**Modification Request for Chester Hill Materials Recycling Facility
(MP 06_0052 MOD 3)**

Thank you for your letter dated 19 November 2018 inviting Transport for NSW (TfNSW) to review and provide comment on the subject matter.

Figure 3.1: Proposed Site Layout

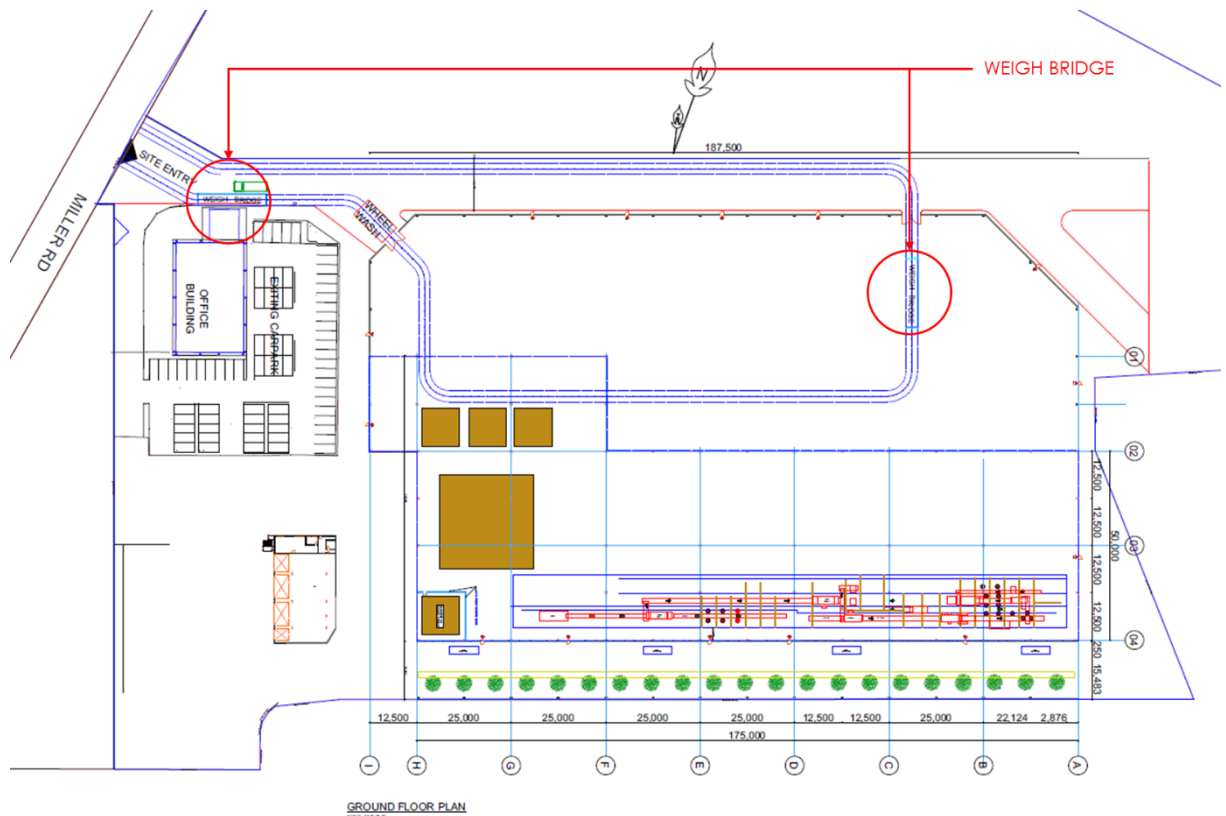
The Environmental Assessment (EA) states that the existing site access arrangement will be retained and the Traffic Impact Assessment (TIA) has identified additional vehicle movements, both light and heavy vehicles, would be generated from the proposed development. The TIA has assessed the intersection performance at the site access, however, there is no consideration provided in regards to the potential vehicular conflicts that might arise from the existing car park access being located next to the site access particularly with the increase of light and heavy vehicle movements. There is potential that heavy vehicles waiting to exit onto Miller Road would block access to the car park resulting in light vehicles blocking the site access/queuing onto the public road.

The applicant should review the proposed site layout to reduce conflicts near the site entry.
